**Kemps Creek Warehouse, Logistics and Industrial Facilities Hub Mod 3 (SSD-9522-Mod-3)
Request for additional information**

I refer to the Modification Report for the Kemps Creek Warehouse, Logistics and Industrial Facilities Hub (SSD-9522-Mod-3). The Department is requesting that you provide additional information.

Attachment 1

3 Lot 2 WH2 - Receiving Office and Workshop
1:100 @B1

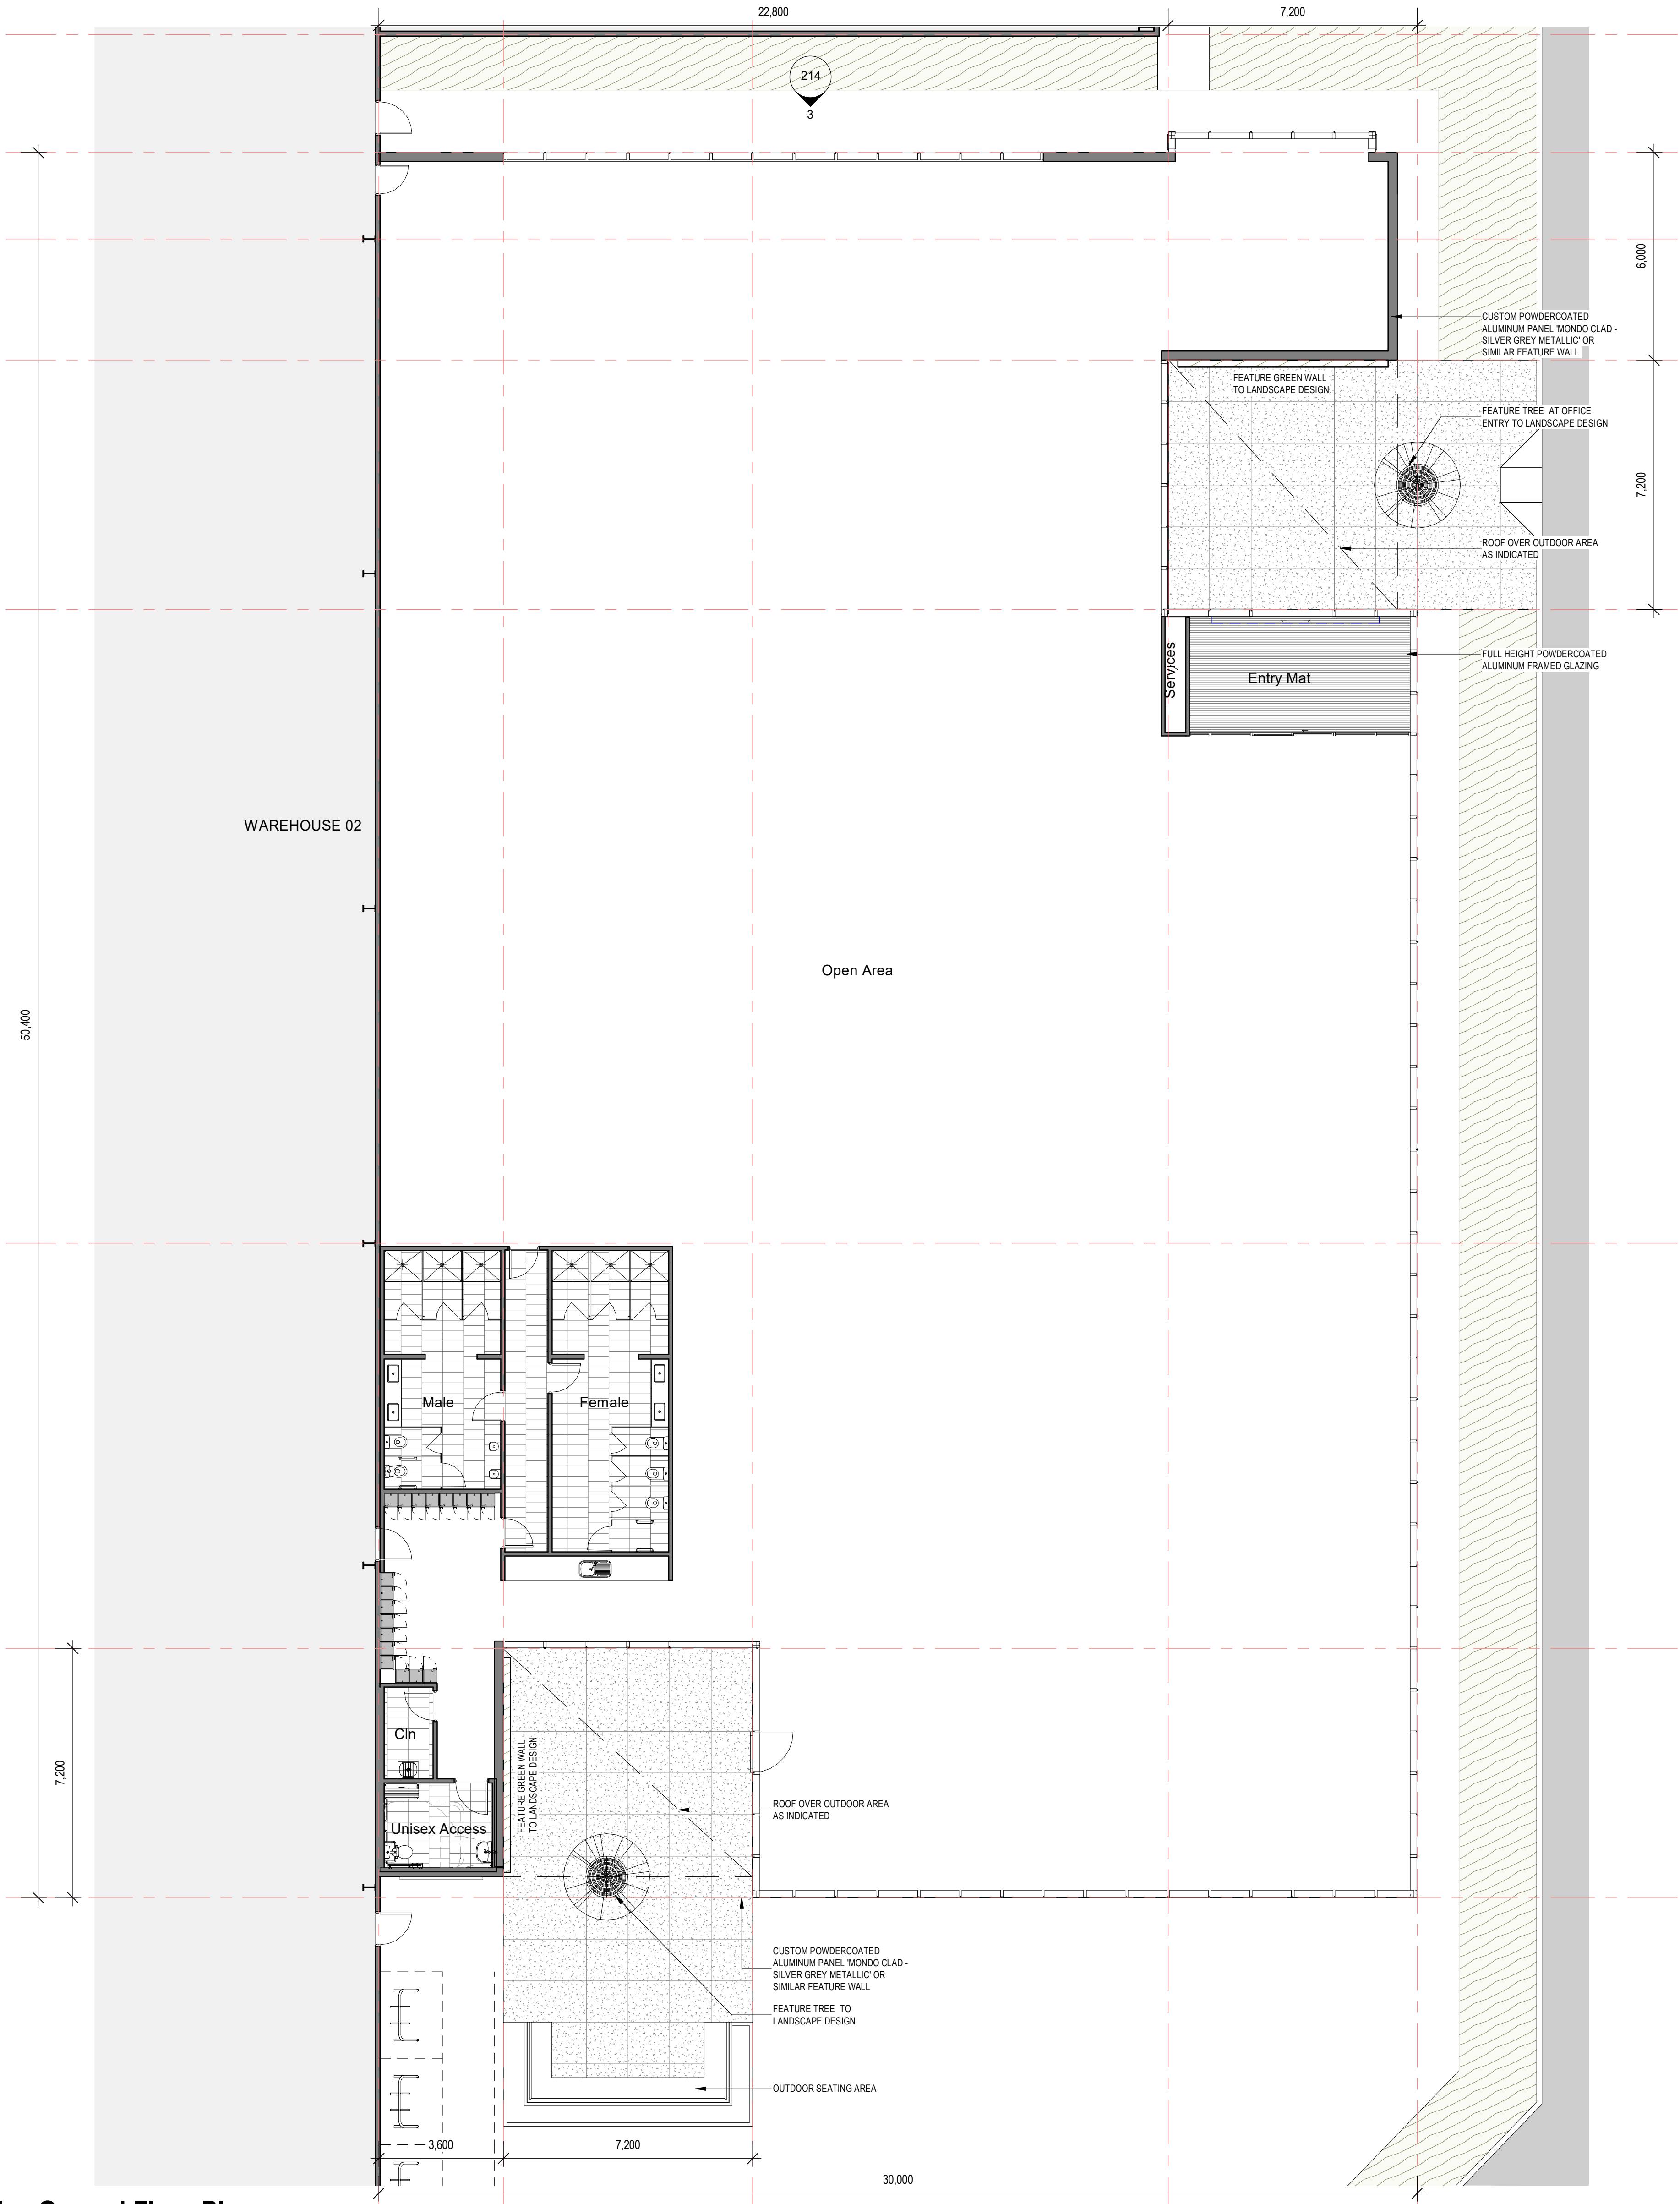
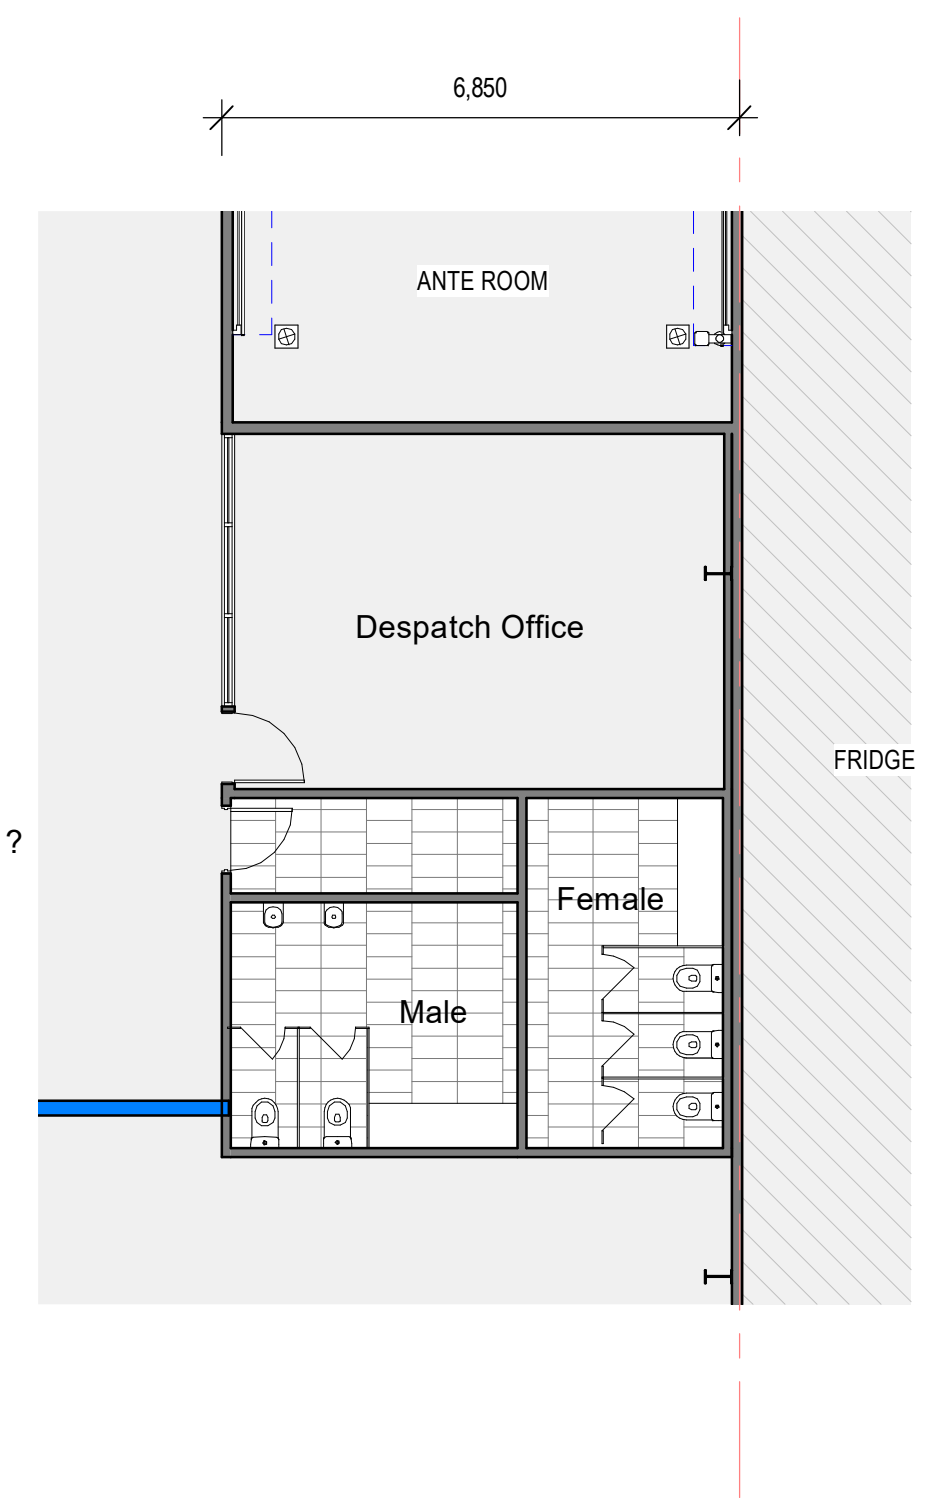
- Please provide justification for the increase in car parking spaces while the overall GFA is proposed to be reduced.
- Clarify why the receiving office and despatch office for Lot 2 are included in the warehouse floor area and not office floor area; similarly, the dock office for Lot 4.

1 Lot 2 South Elevation (Bakers Lane)
102 1:400 @B1

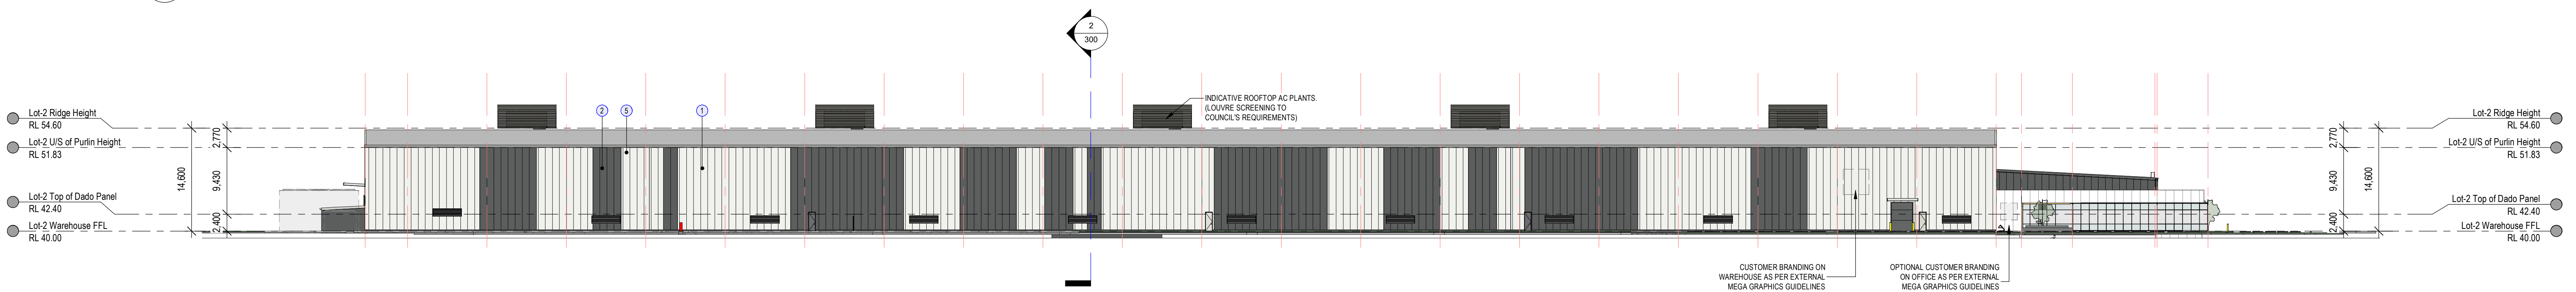
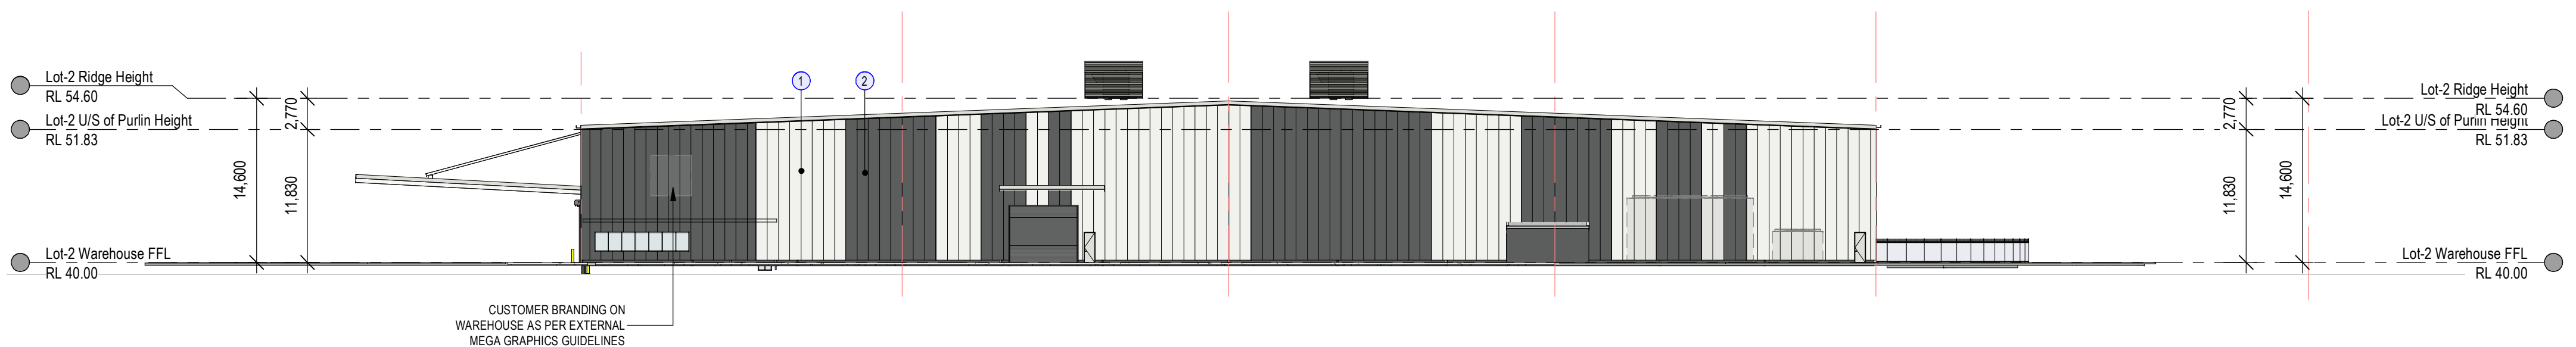
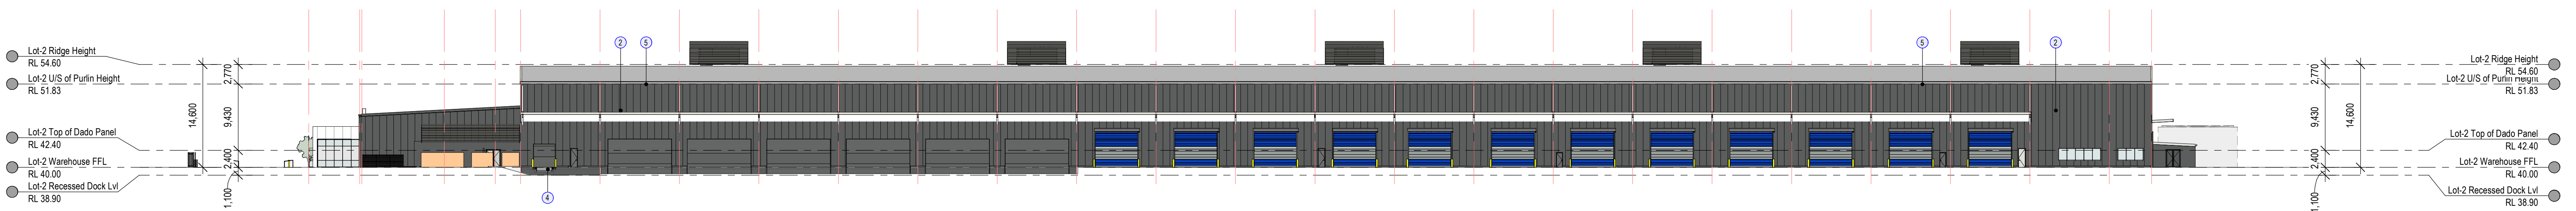
- Please provide updated details for any proposed signage with regard to Condition B90. It is noted that the elevations in the architectural plans at Appendix A include notes referencing 'external mega graphics guidelines' – please clarify.

- The modification report states that the development will retain the same materials and finishes as approved previously. However, the external finishes identified in the architectural plans at Appendix A are different to those shown on previously approved plans for Lots 1-4. Please clarify.

1 Lot 4 South Elevation
102 1:400 @ 81

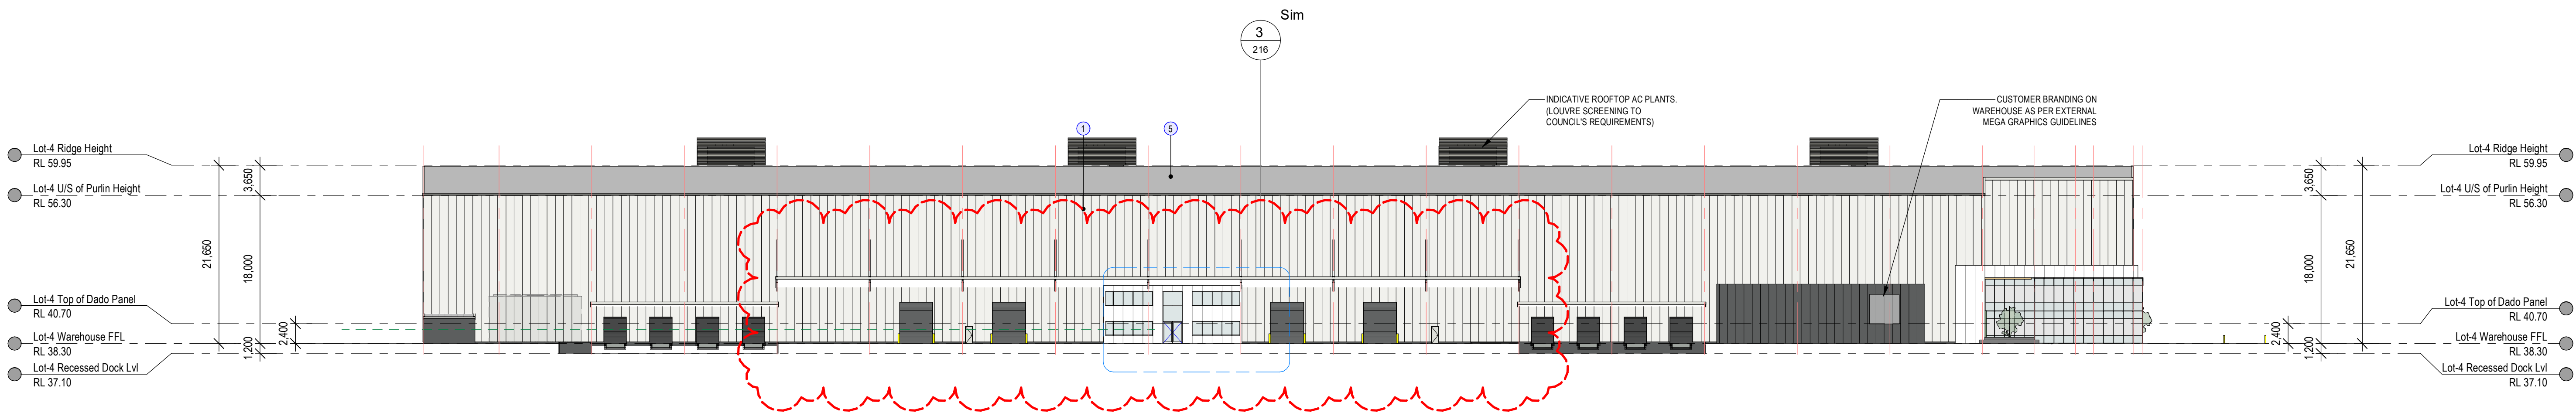
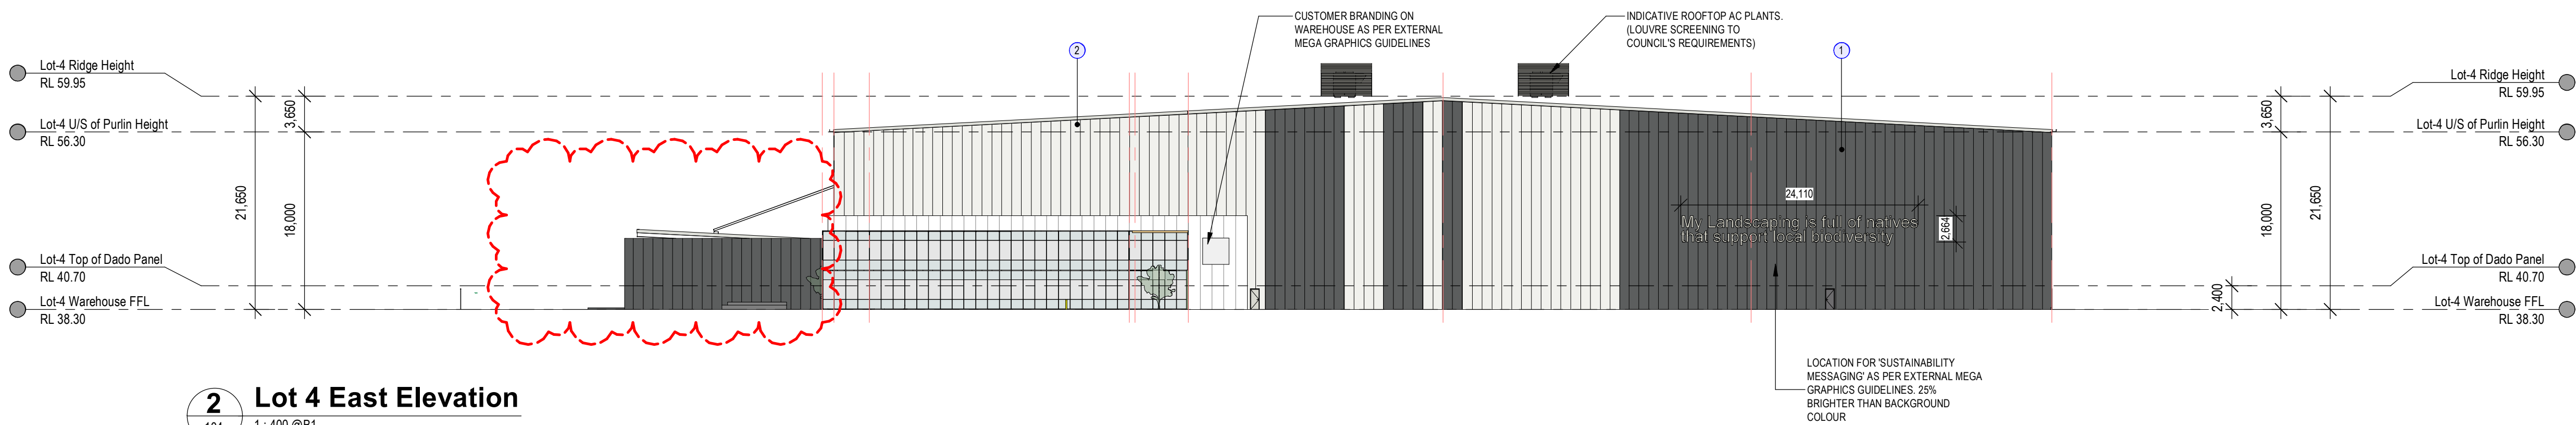
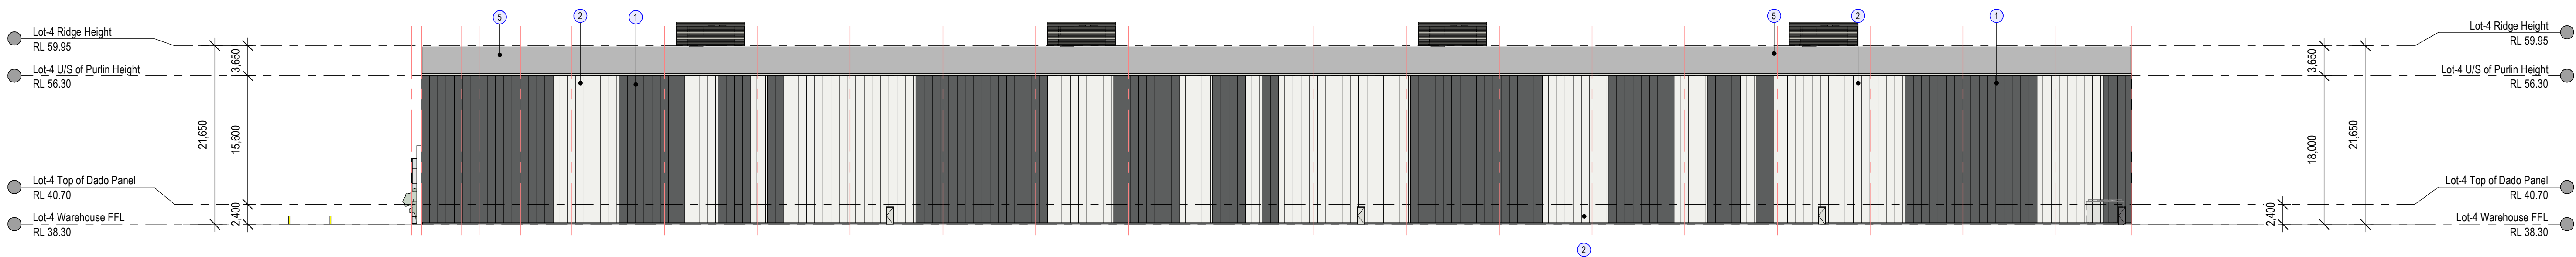
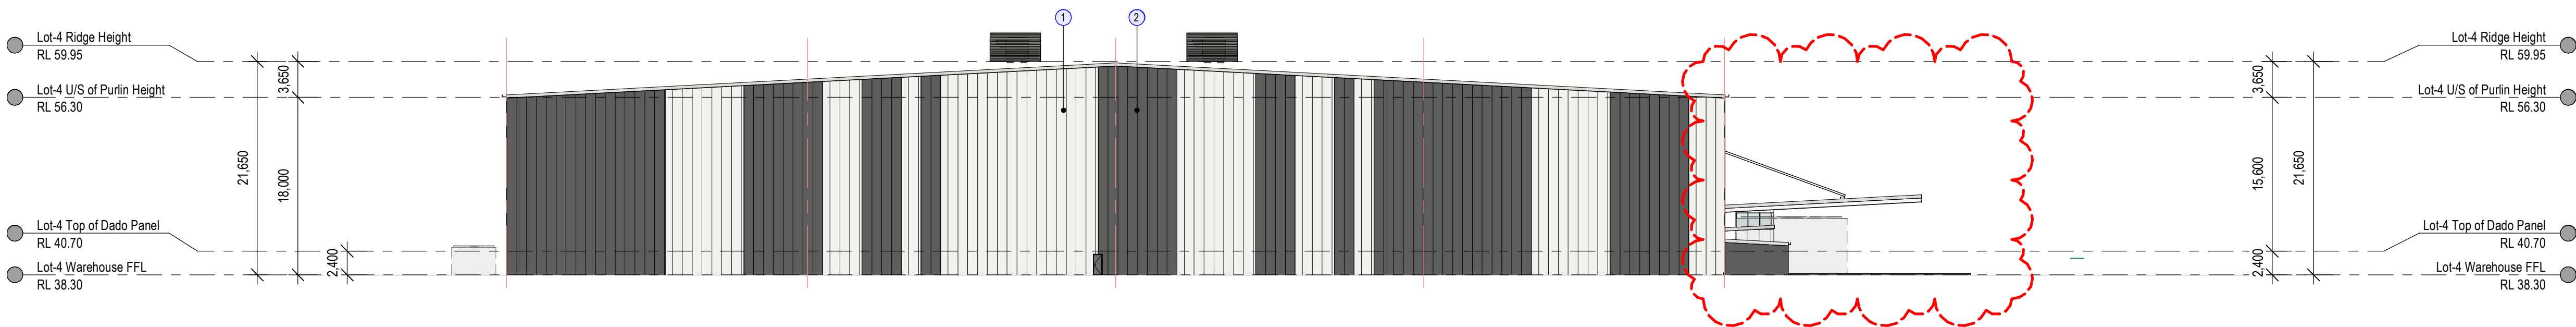
- The proposed awning and columns within the setback area do not comply with the development controls in Condition A7.
- The Visual Impact Assessment (Appendix B) should include consideration of the rooftop plant proposed for Lots 2 and 4.
